Your Ref: OWPC22125
Our Ref: A/31/19/PL 01-03-2019
Please ask for:
Mrs A Gardner

1 No. two storey house (resubmission following A/87/18/PL). This application is a Departure from the Development Plan & affects a Public Right of Way.

Land between Ashurst & Badgers Ham Manor Way Angmering

Side Elevation (south)

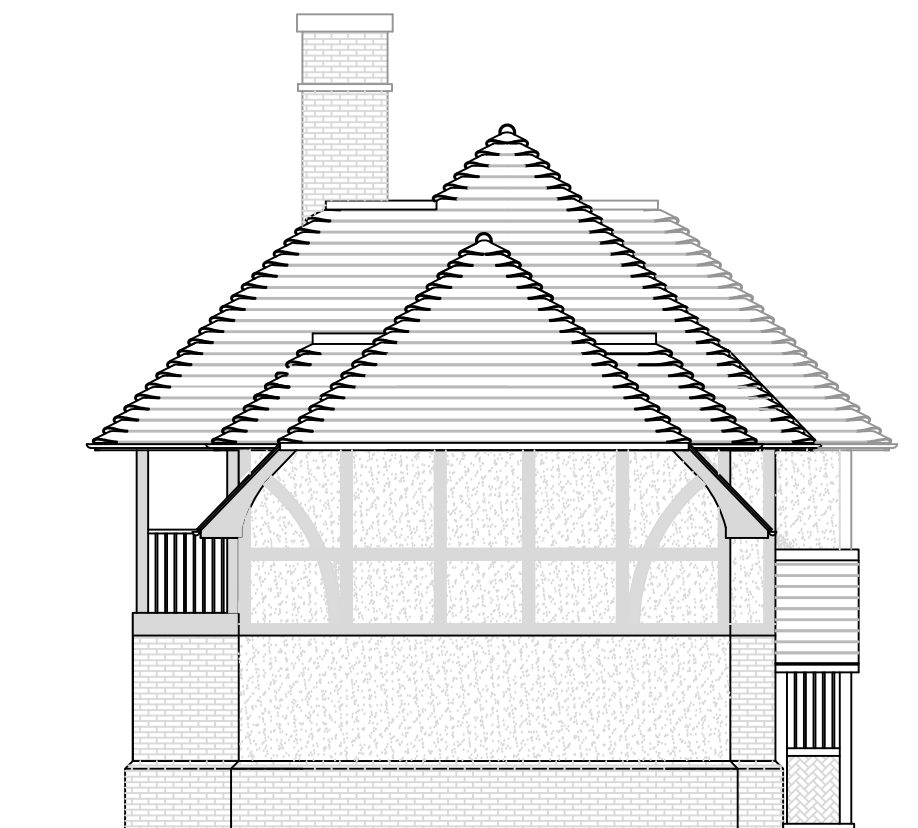
** The applicant has submitted plans for one house on one of the plots covered by the CLD stating that the remaining plot is to be used as a garden for the dwelling. However, the plans do not provide for any windows or doors on the garden south side of the dwelling. It is quite clear from the plans and drawings that, if the applicant is successful with this application, it will only be a matter of time before another application will be submitted for a second large property to be built on the remaining "garden" plot. Should the council be of a mind to grant this application, then in order to maintain the dwelling to plot ratio and the open nature of the location, consideration should be given to the issuing of a section 106 notice to cover the adjoining garden plot.*

Street Elevation (1:200)

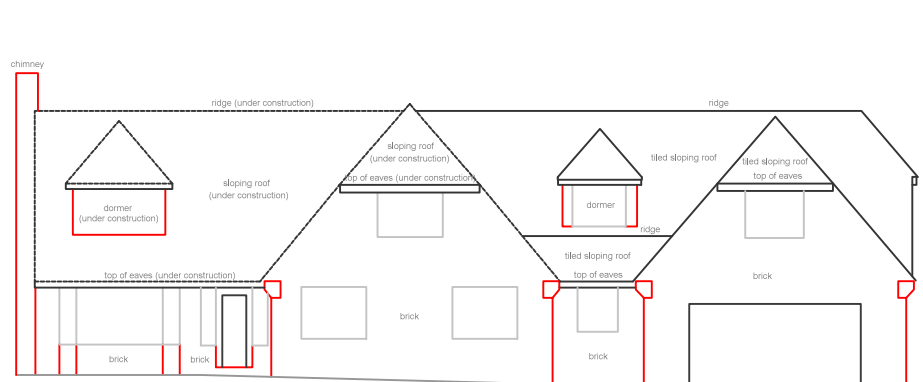
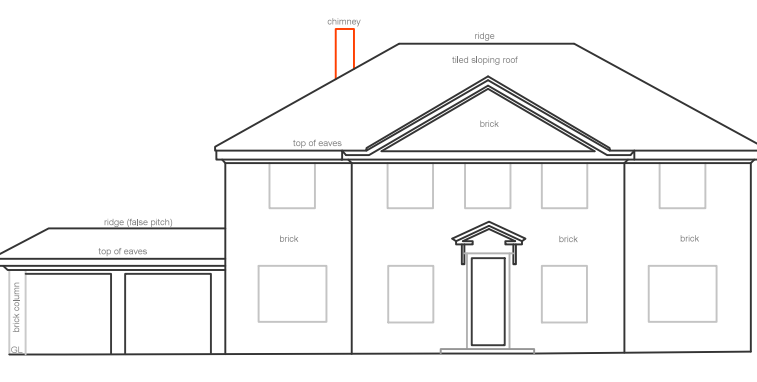
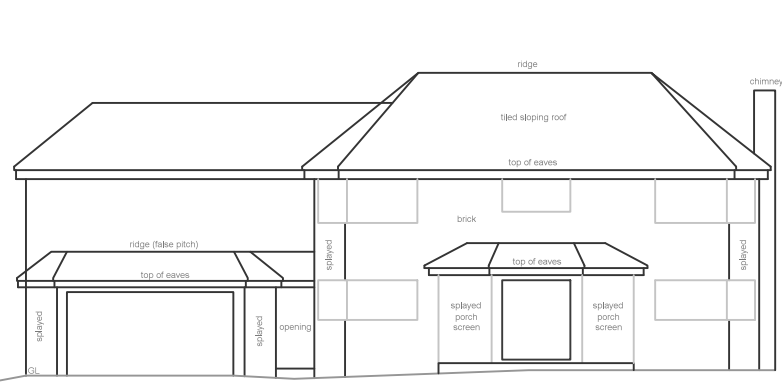
** The applicant makes much of the fact that the proposed dwelling is similar in size and design to Badgers, the nearest house situated to the north of the site. Yet, opposite and adjacent to the site, all the other remaining properties are much smaller in size and of bungalow or chalet/bungalow design. The proposed dwelling will be totally out of keeping these surrounding properties.*

** In conclusion, Ham Manor Way is a public Right of Way and as such is used by many villagers and residents for recreation and walking of dogs. Building of the proposed dwelling, with such a high and wide frontage would greatly diminish the striking views afforded across the golf course and the open countryside beyond.*
